Application by Fosse Green Energy Limited for the Fosse Green Energy

The Examining Authority's first written questions and requests for information (ExQ1)

Issued on 14 January 2026

Drawing file: published-documents / EN010154-000170-6.2 Fig 8-5 Bird Mitigation Land Allocation.pdf

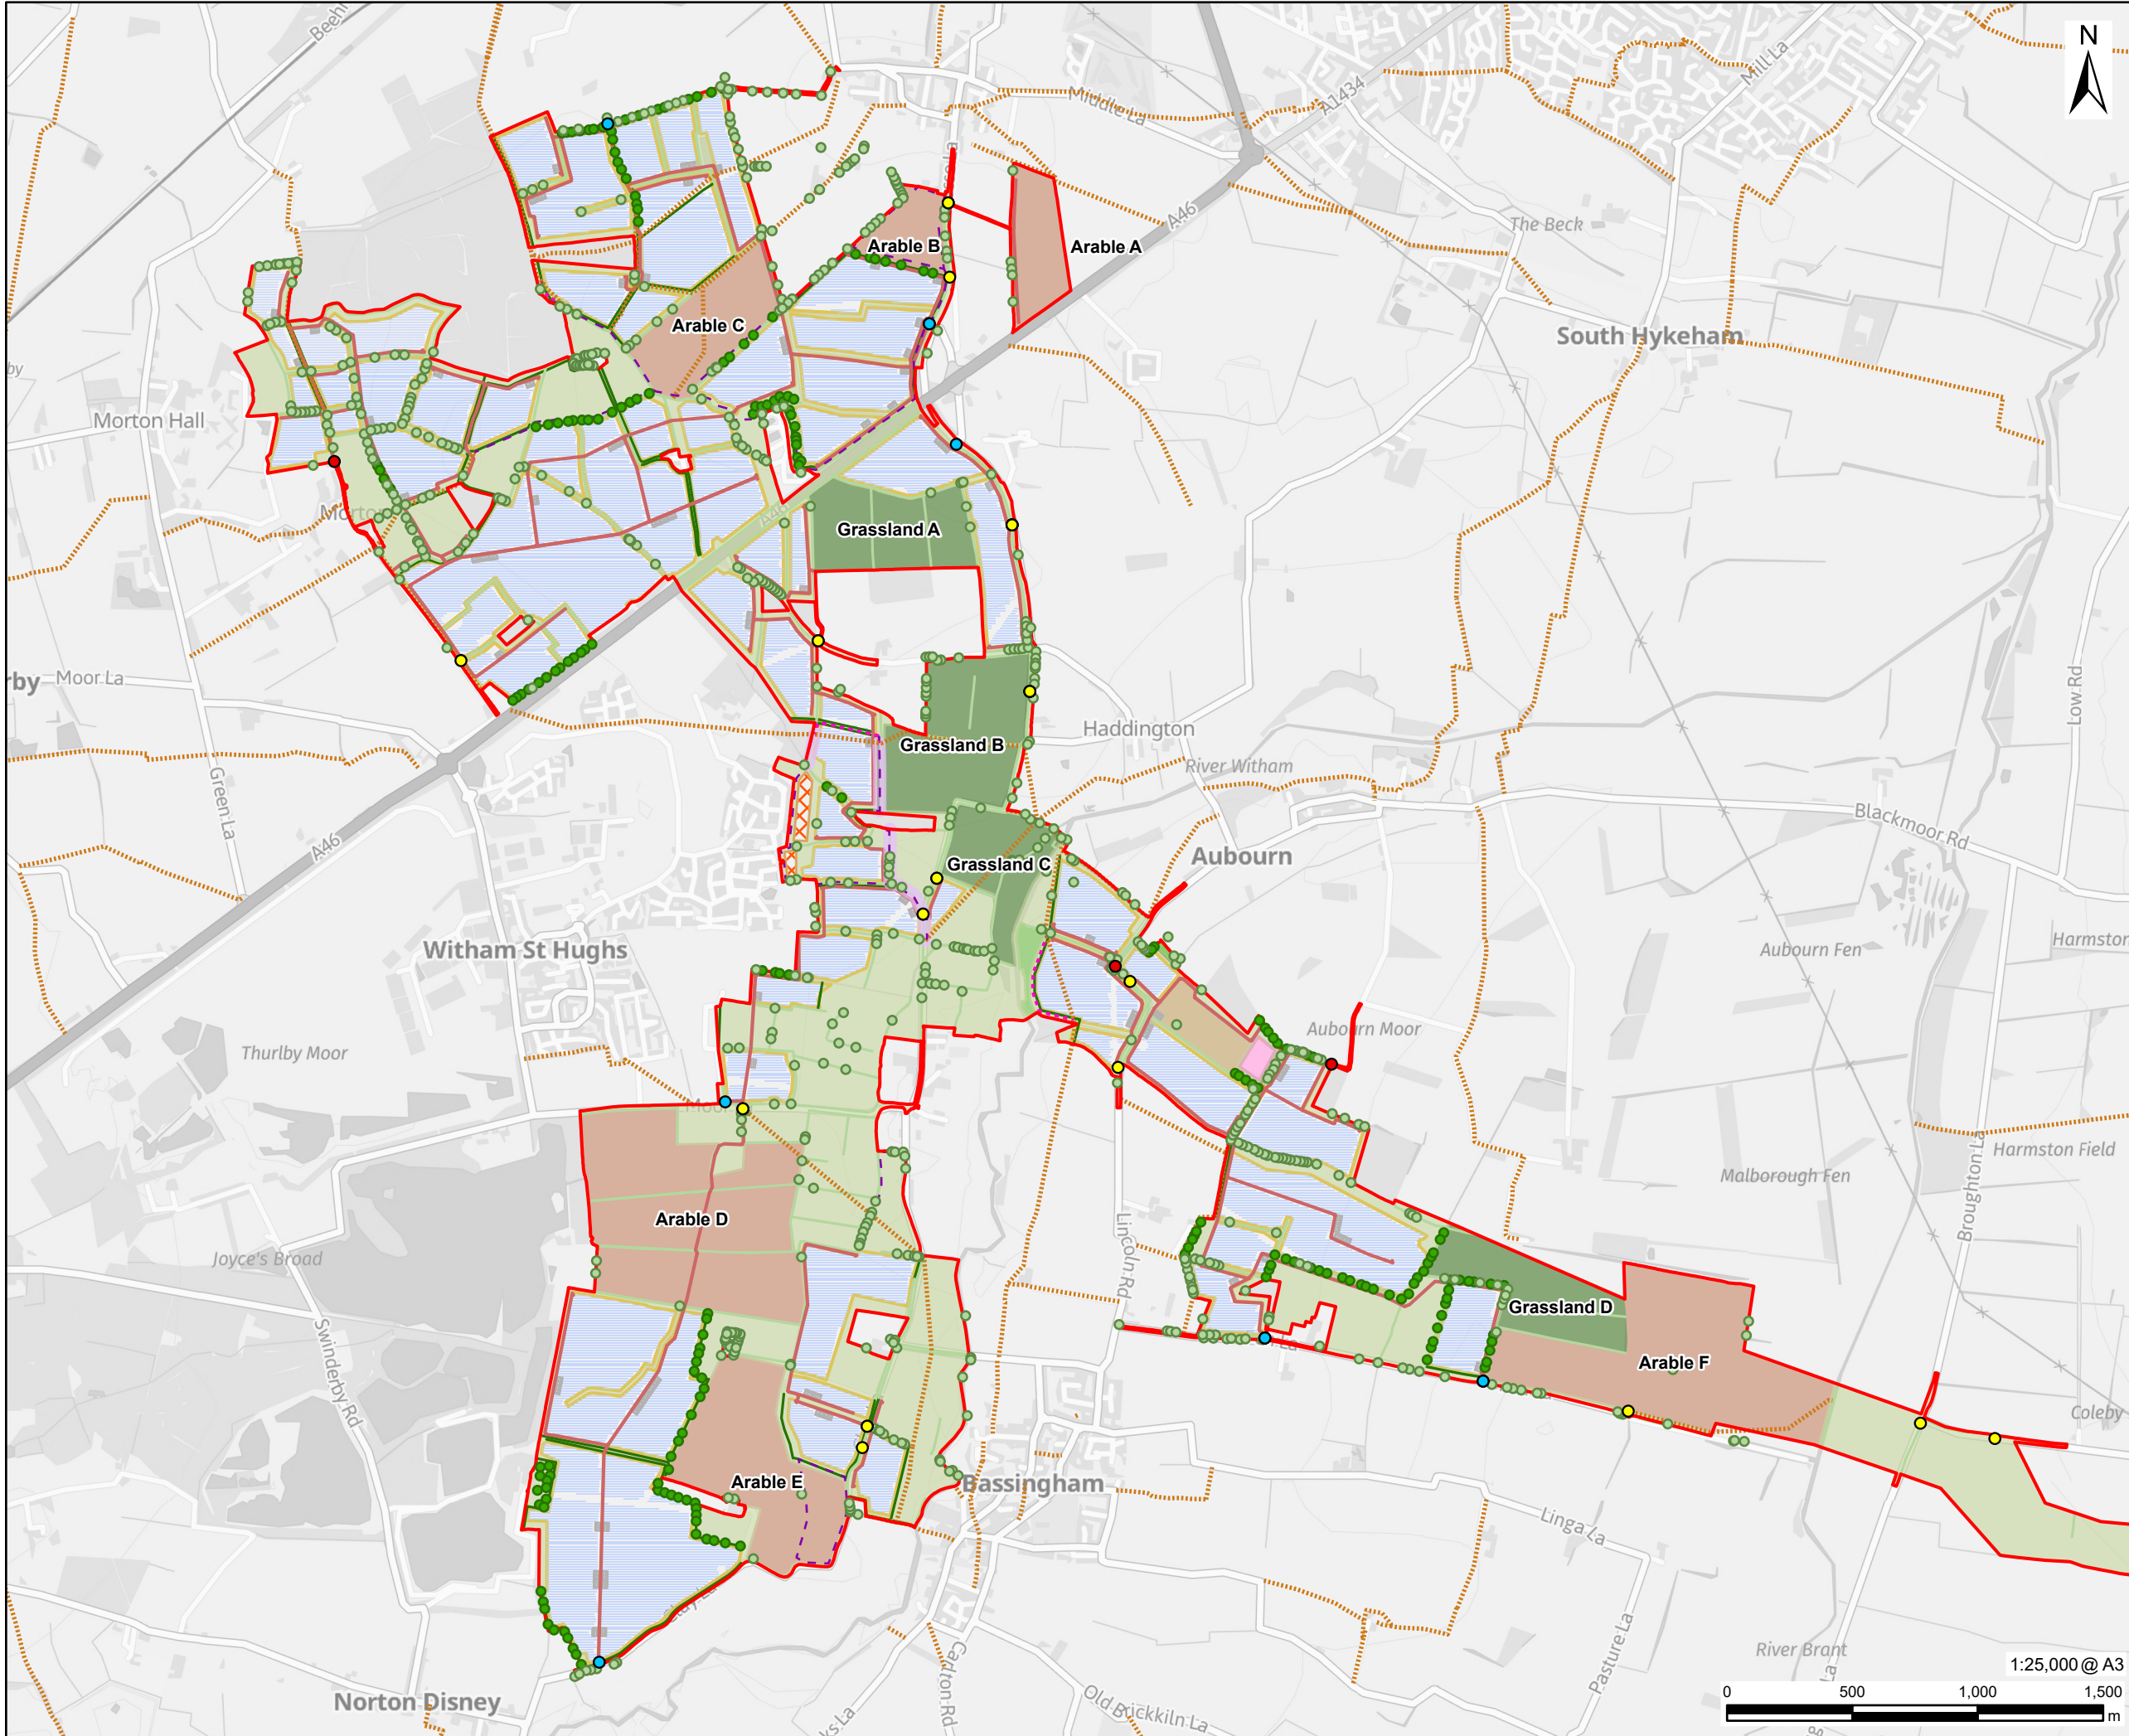
ENC.1.12	Applicant	<p>Mitigation – ground nesting birds</p> <p>Figure 8-5: Bird Mitigation Land Allocation [AS-046] identifies areas of permanent grassland (grassland A to D) and managed arable (arable A to F) as the bird mitigation areas.</p> <p>Figure 7.15-1 of the FLEMP [AS-101] identifies “bird mitigation areas – permanent grassland” and “bird mitigation areas – managed arable” which appear to be the same as the areas of permanent grassland and managed arable in Figure 8-5.</p>

Question Number	Question to:	Question
		<p>The post development habitat plan in Appendix D of the Biodiversity Net Gain (BNG) Report [APP-194] identifies “grassland – other neutral grassland” and “cropland – cereal crops” which appear to be the same as the areas of permanent grassland and managed arable in Figure 8-5.</p> <p>Paragraph 4.2.4 of the FLEMP [AS-101] advises that there would be approximately 83 hectares (ha) of permanent grassland for bird mitigation purpose, while paragraph 5.3.57 states that a minimum 64ha of permanent grassland would be created, although the size of Area D would be confirmation.</p> <p>Paragraph 5.2.18 identifies that a minimum of 181ha of managed arable would be provided for bird mitigation purposes.</p> <p>Paragraph 3.3.4 of the BNG Report [APP-194] states that 124.82 ha would be utilised primarily for bird mitigation (Cropland and Grassland habitats) by offering a variety of flowering plants that support pollinators and serve as a food source and nesting habitat for numerous bird species.</p> <p>Explain:</p> <ul style="list-style-type: none"> a) the relationship between the various documents referred to in this question b) the reasons for the differences in the figures identified in the FLEMP and BNG Report c) how the areas identified as bird mitigation have been considered in the BNG Report <p>The ExA considers the applicant’s response to point c) should be included in the technical note to be submitted as an action arising out of the holding of ISH1.</p>
